TRANSPORTATION MEMORANDUM

**Timbers at Black Forest
El Paso County, Colorado**

PCD File No. P269

April 2026

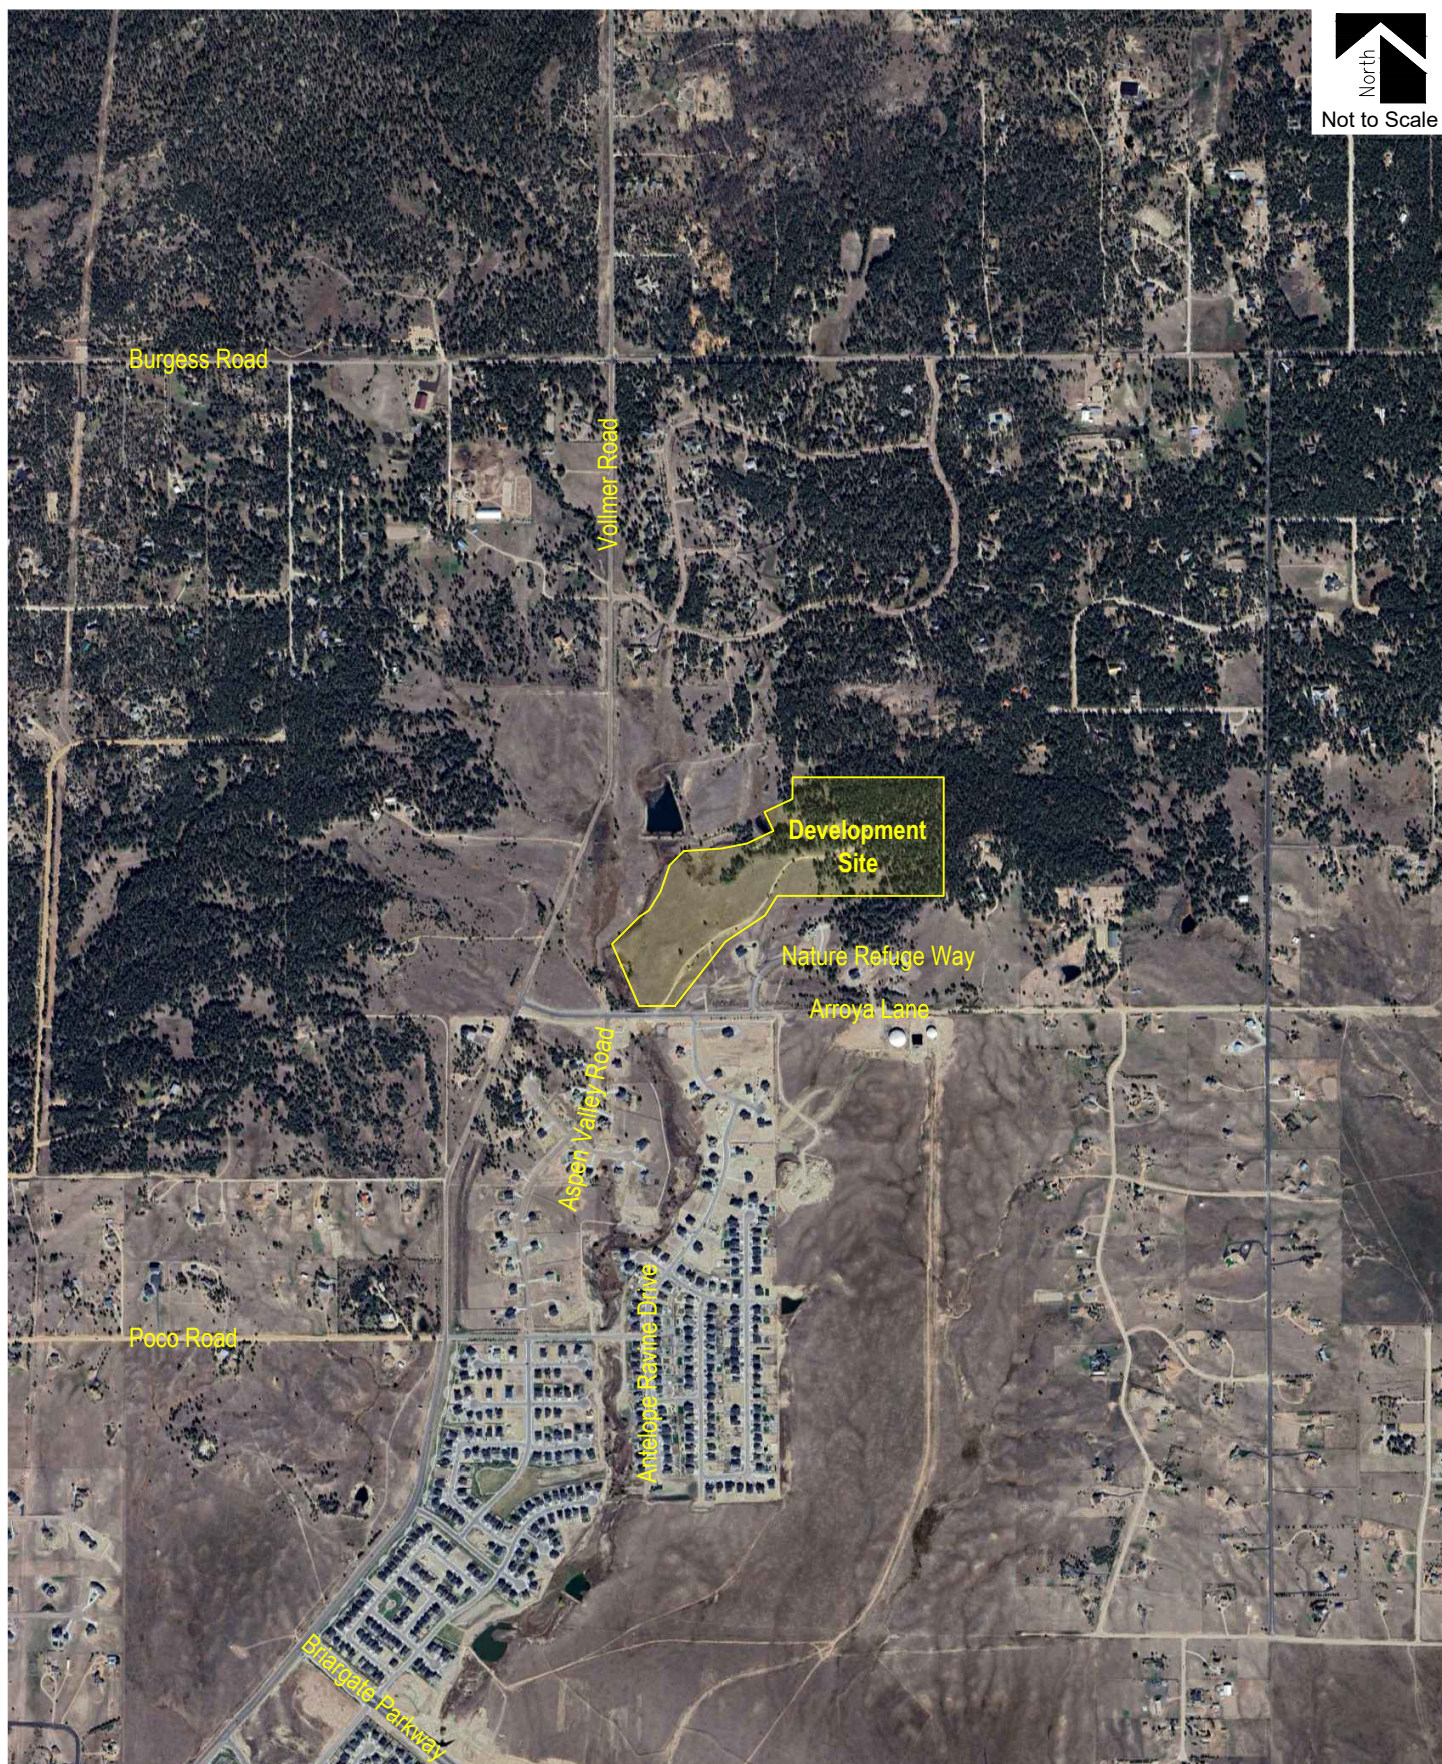
3 parcels exist and take access from the proposed roadway.; parcels to the north are land locked- do they have easements to this road? Does that take project over 25 lots?

Figure 4
BACKGROUND TRAFFIC - YEAR 2028
Volumes & Intersection Geometry
AM / PM Peak Traffic Hour
(ADT) : Average Daily Traffic

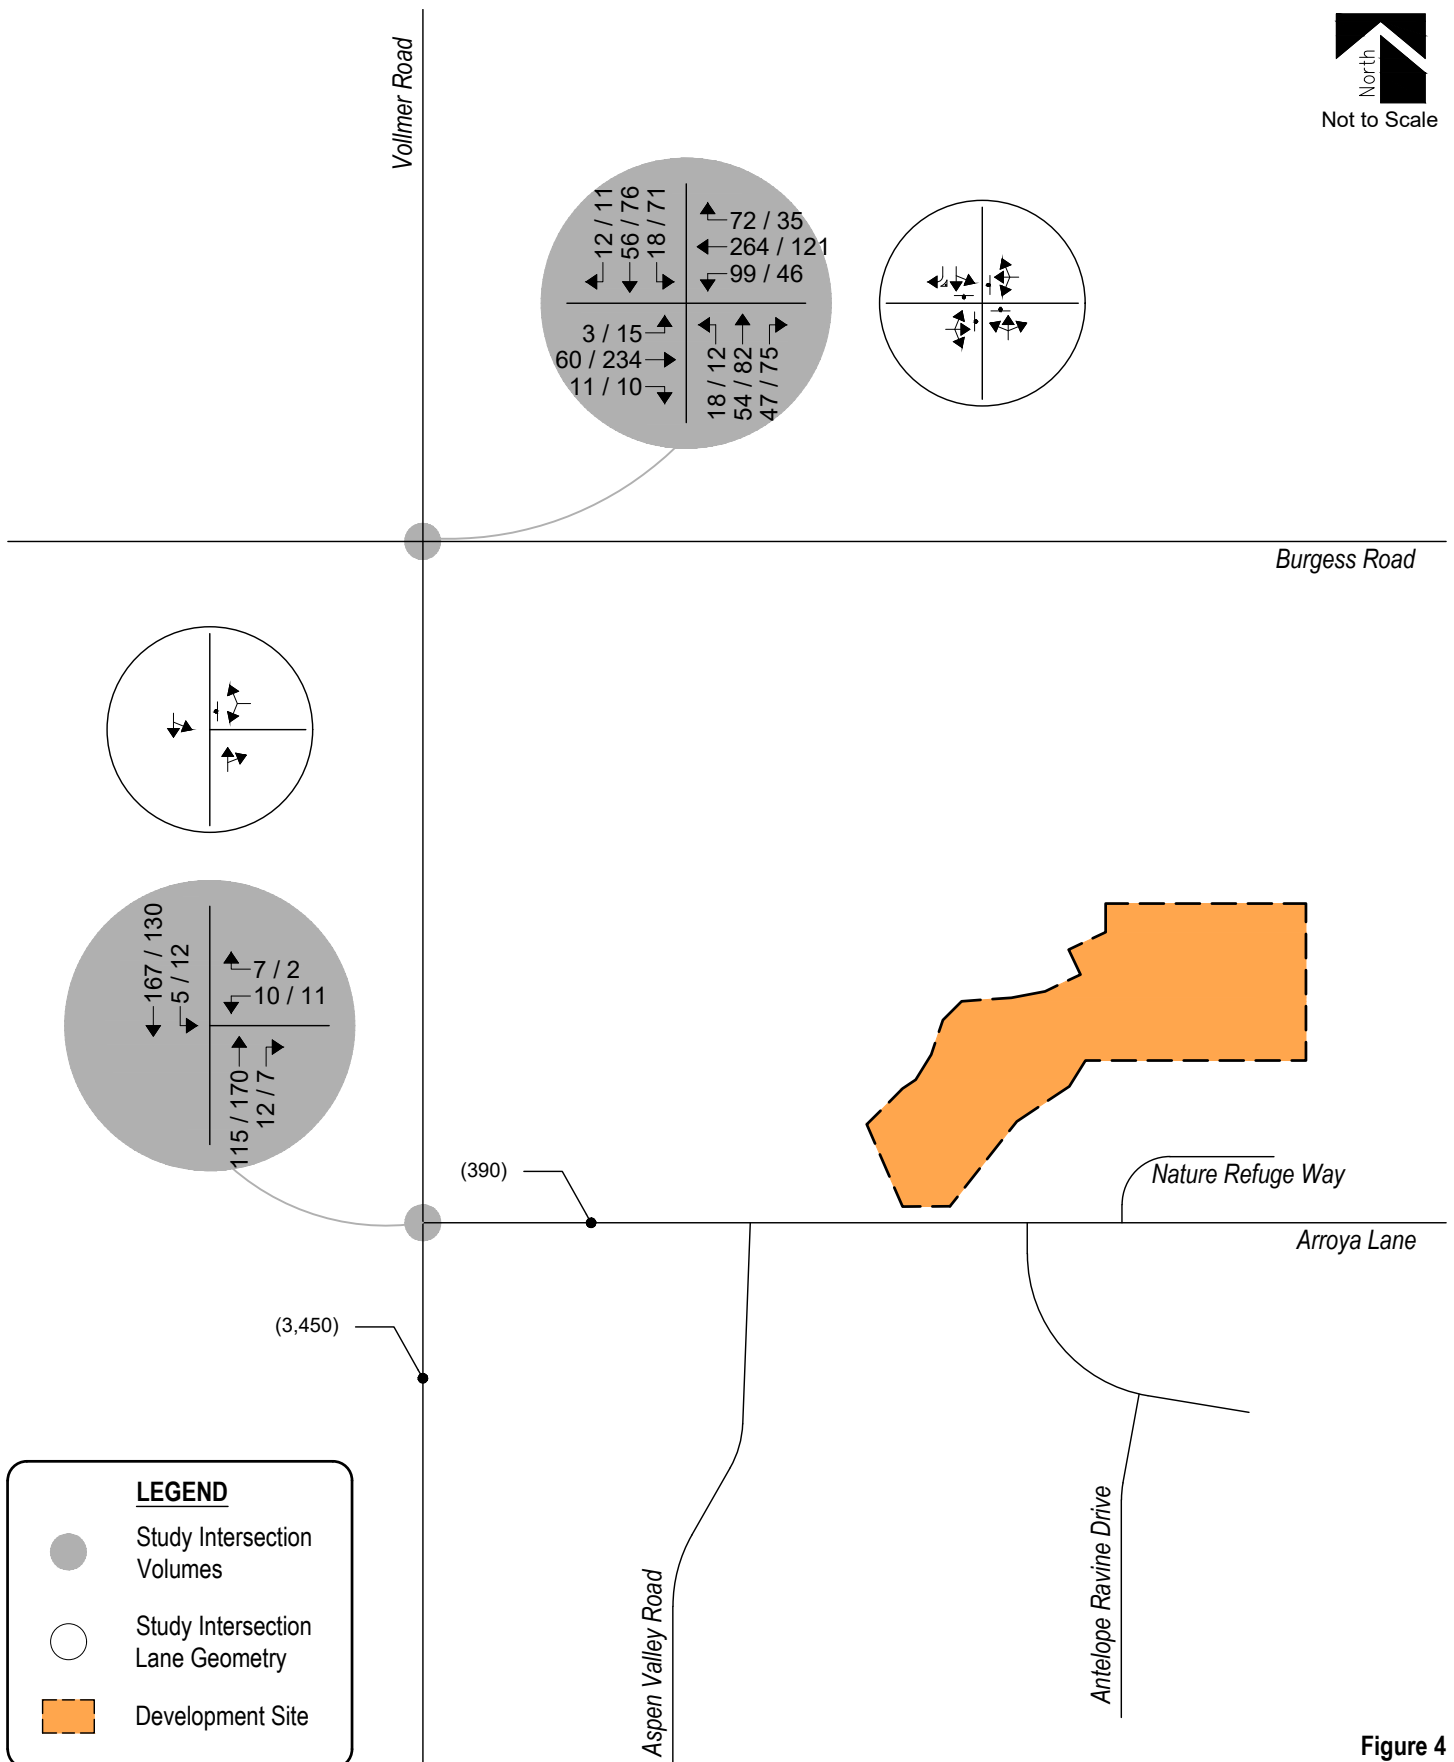
Indicate if Timber Ridge 3 is considered fully built out under existing conditions, or if it's not and a portion of it has been added into the future conditions.
